**Final Acceptance Punchlist**  
**El Paso County – Department of Public Works - Stormwater Section**

Project Name:	Redtail Ranch
EDARP Filing Number(s):	SF1821
ESQCP Number:	ESQ1932
Attendees:	DPW SW: Molly Layshock, Mikayla Hartford, Glenn Reese DPW Dev Services: Developer:
Date of Walk-Thru:	05/18/2023
Walk-Thru Number:	1 <sup>st</sup> FA walk

<p>REDTAIL RANCH FILING NO. 1 DRAINAGE IMPROVEMENT PLANS EXTENDED DETENTION FACILITY NO. 1 OUTLET BOX DETAILS</p>			
DESIGNED BY	MAW	SCALE	DATE 4-15-20
DRAWN BY	MAW	(H) 1" = N/A	SHEET 9A OF 10
CHECKED BY		(V) 1" = N/A	JOB NO. 2525.00

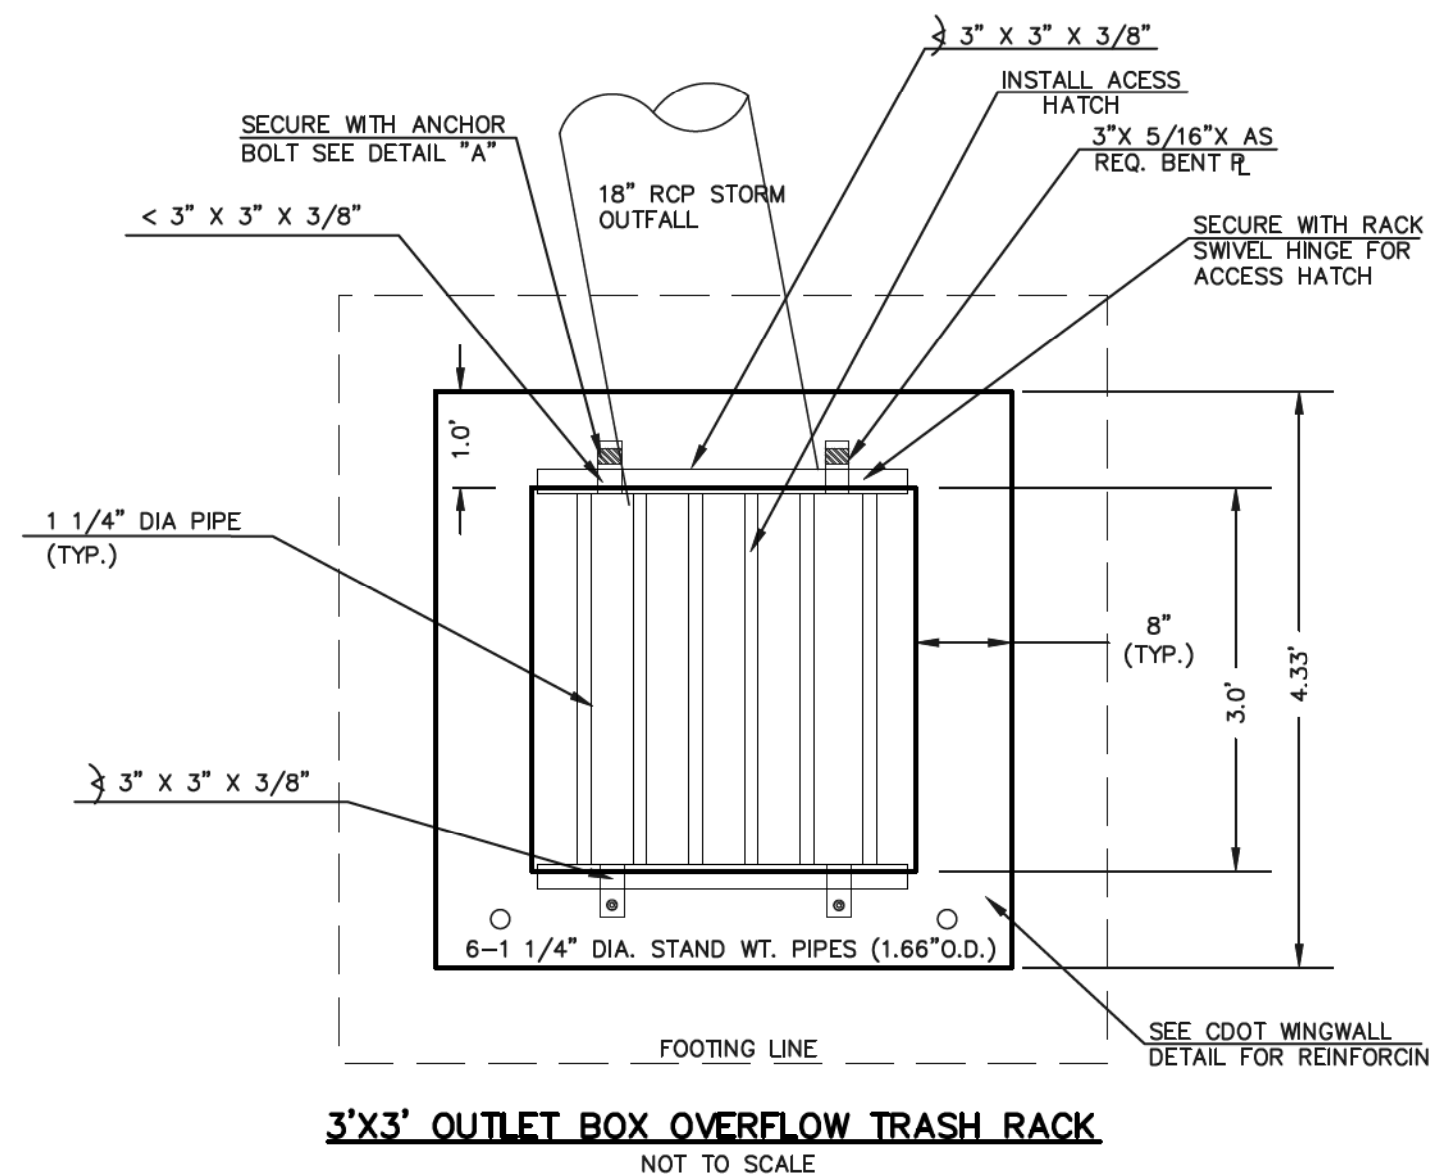
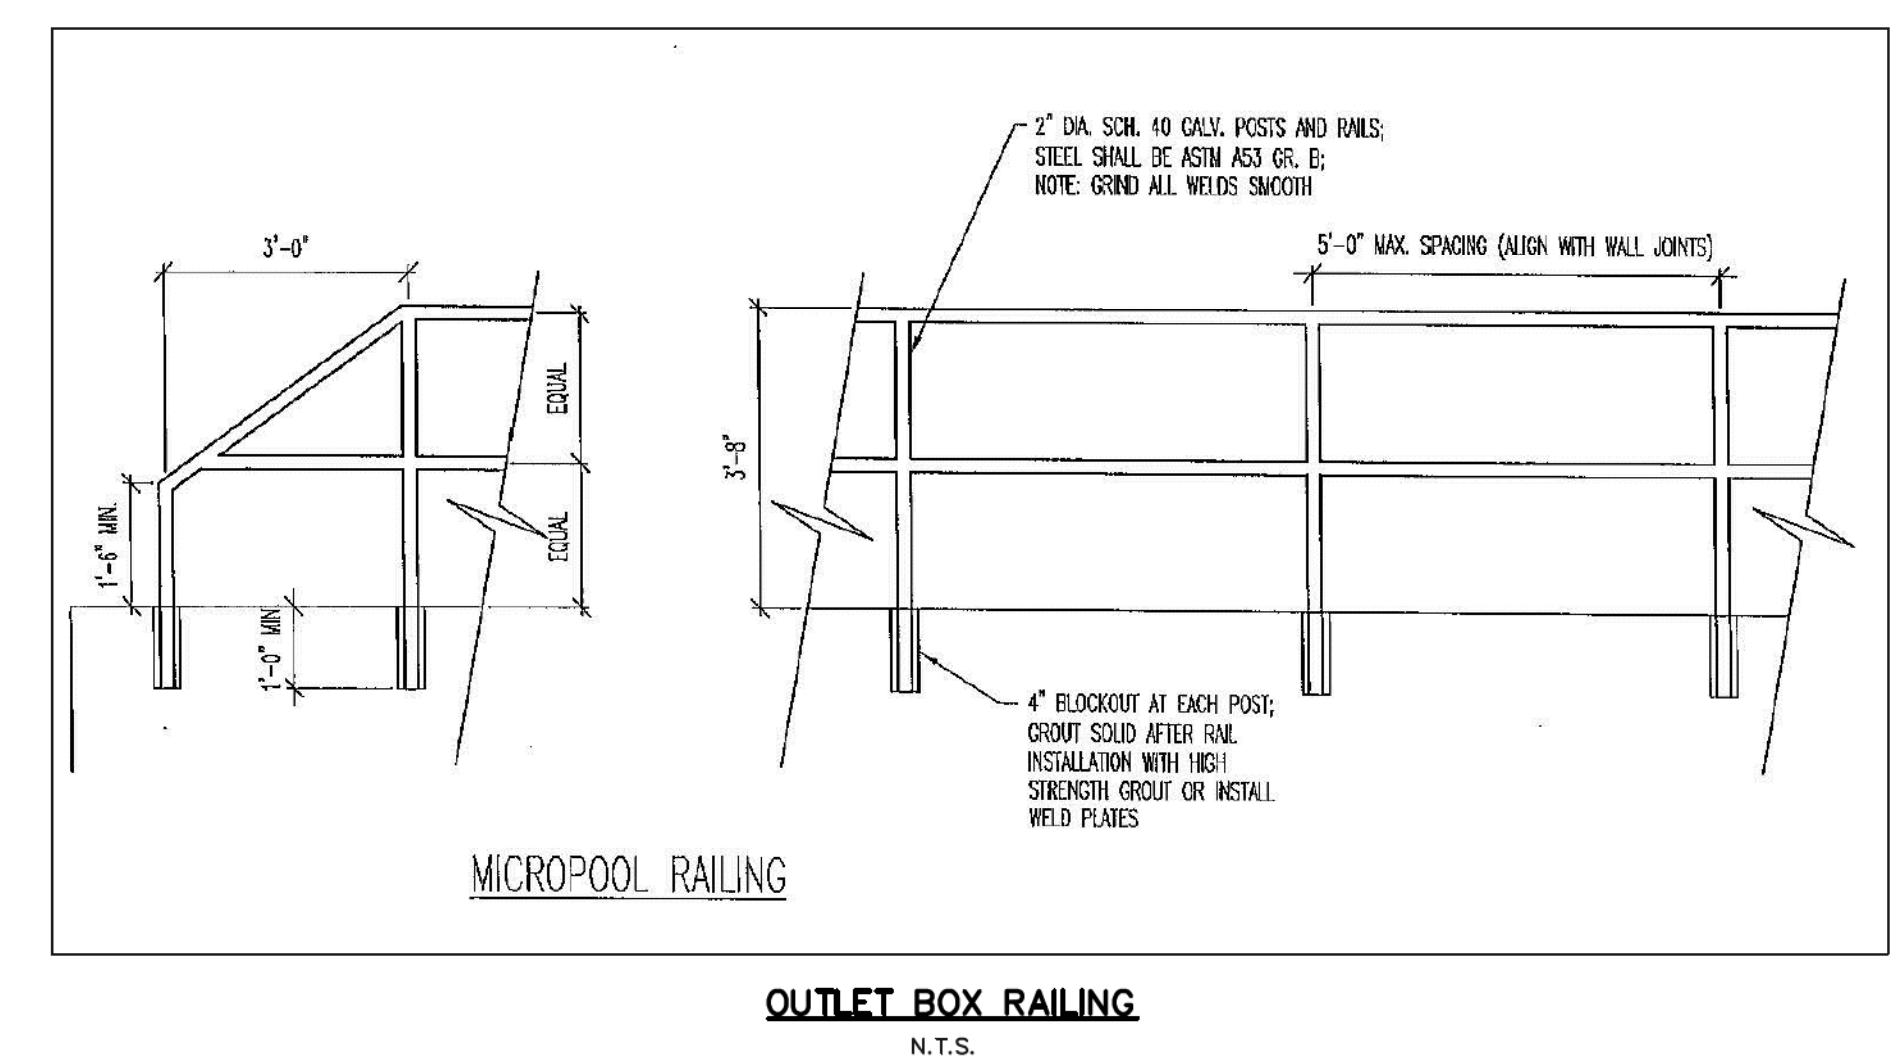
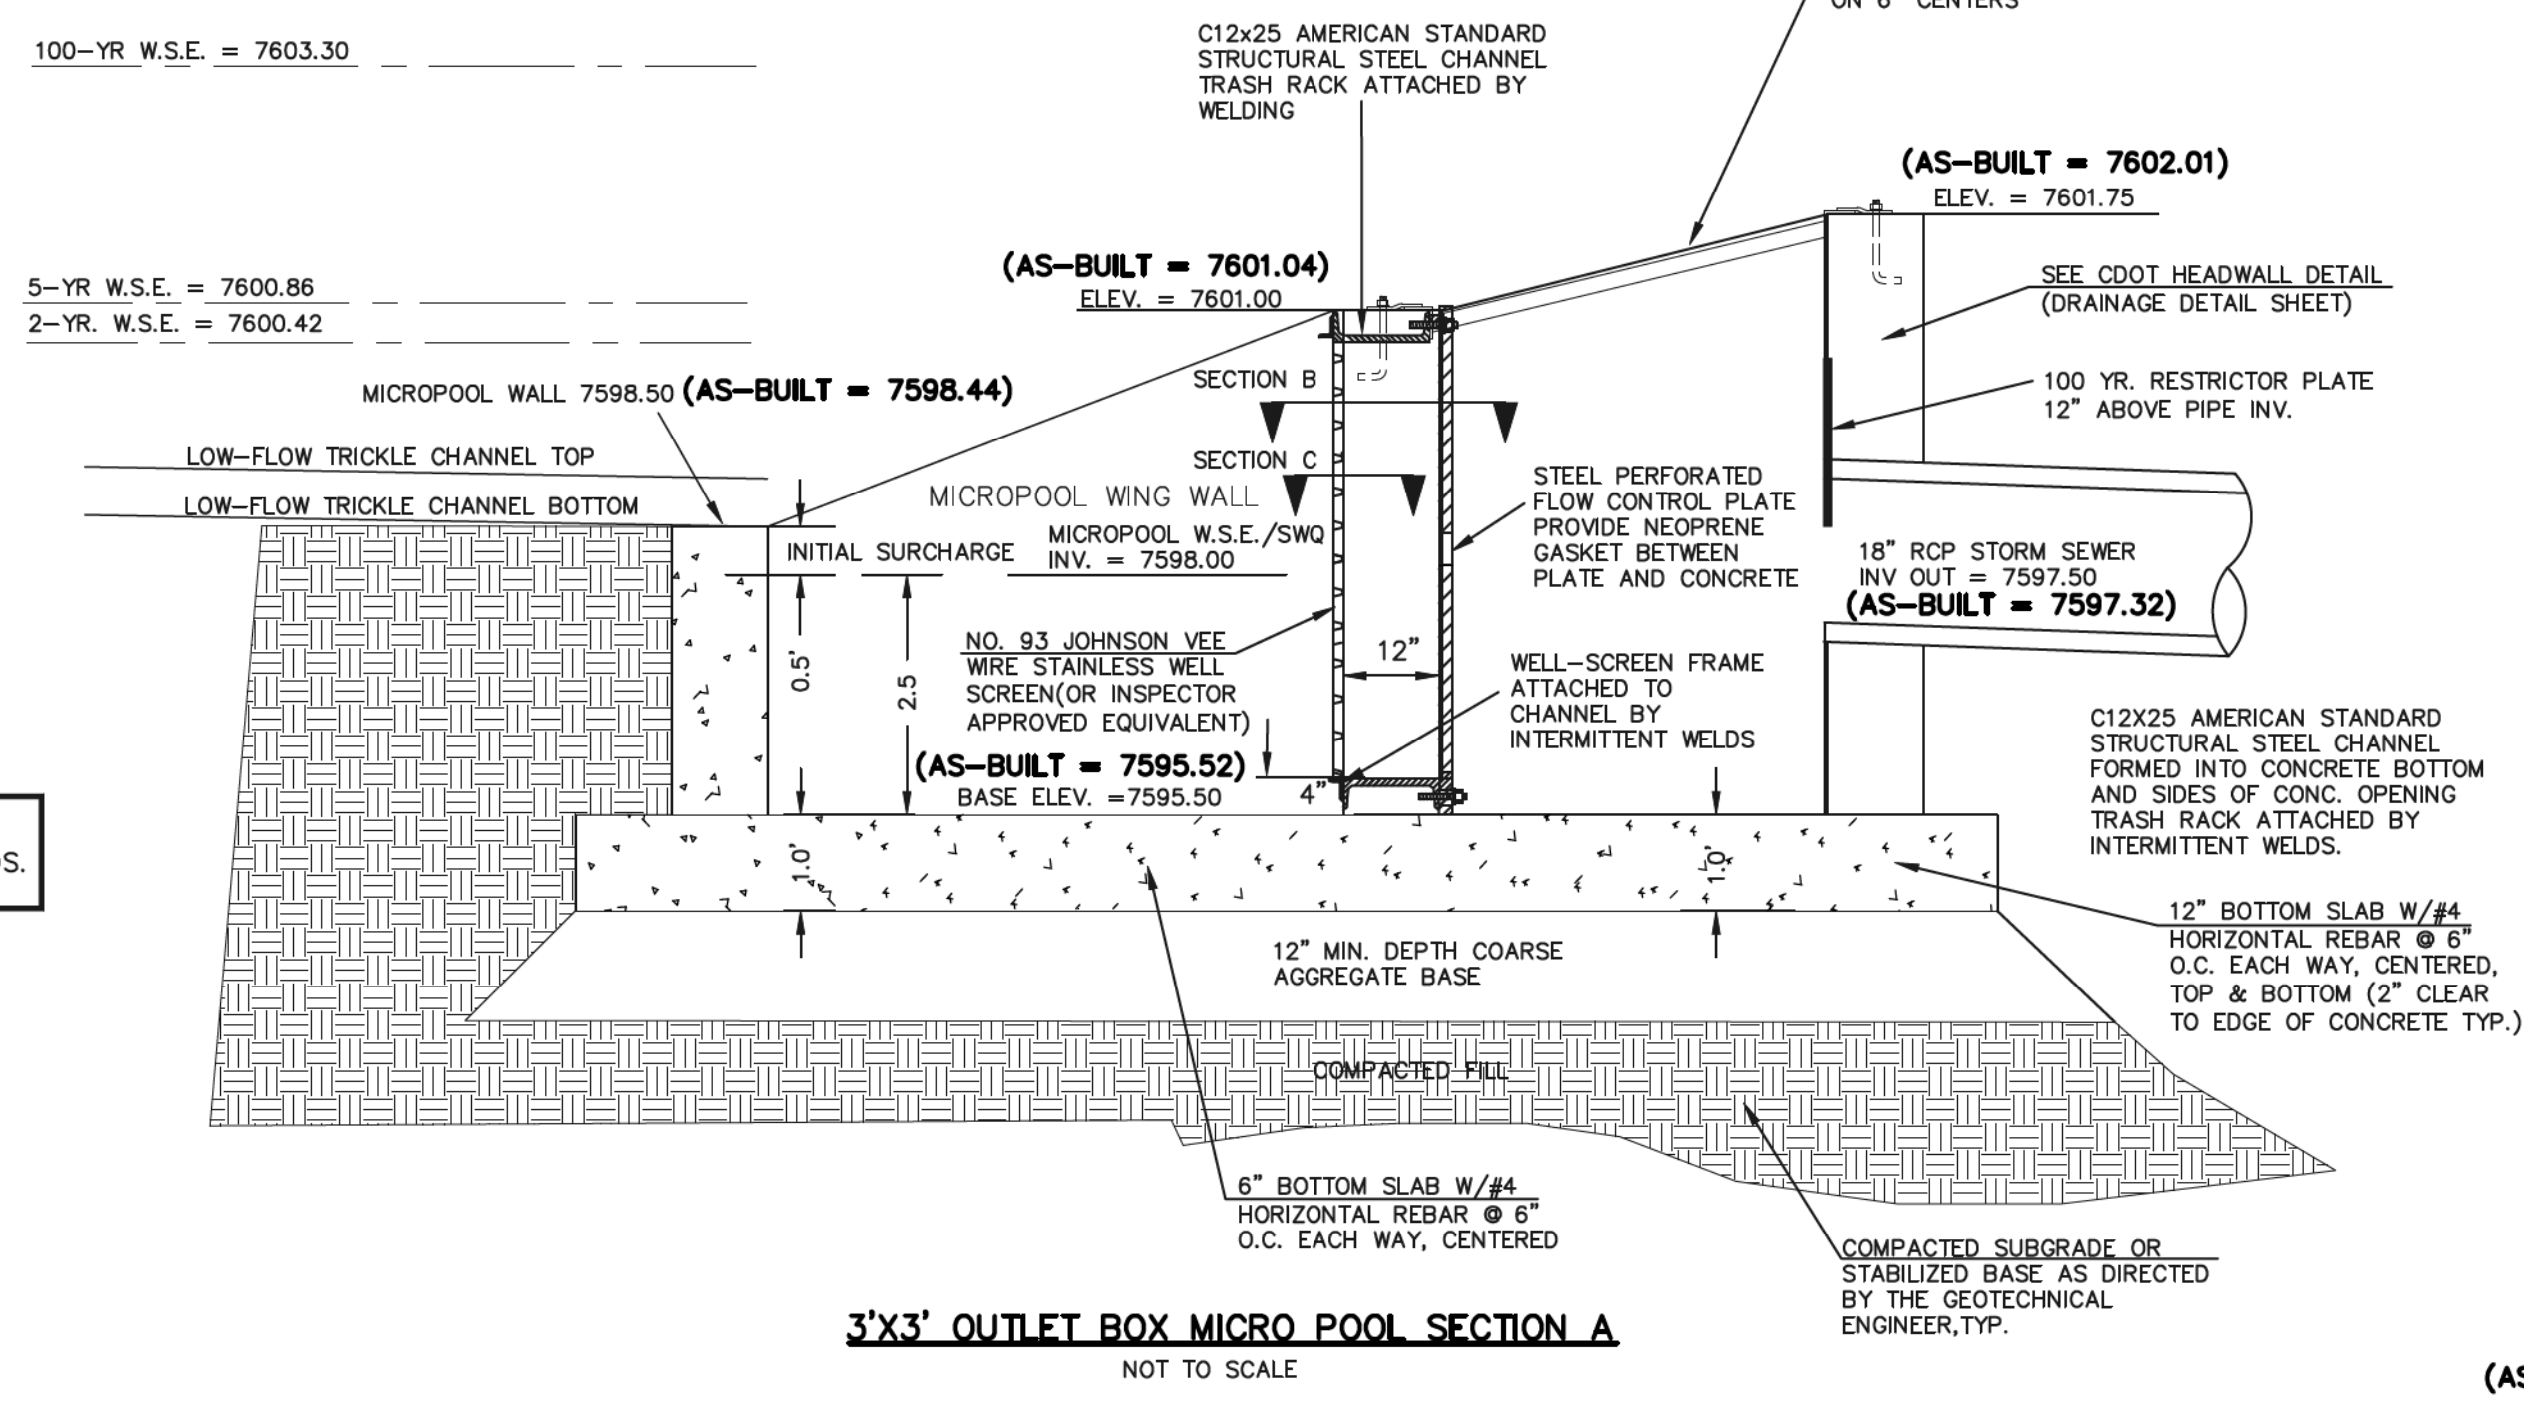
- 19"x60" outlet box orifice plate (sheet 9A of 10) measures 60"x60" in the field. Reflect this change on the as-builts
- Adjust grading at check dams upstream of easterly rundown for positive drainage
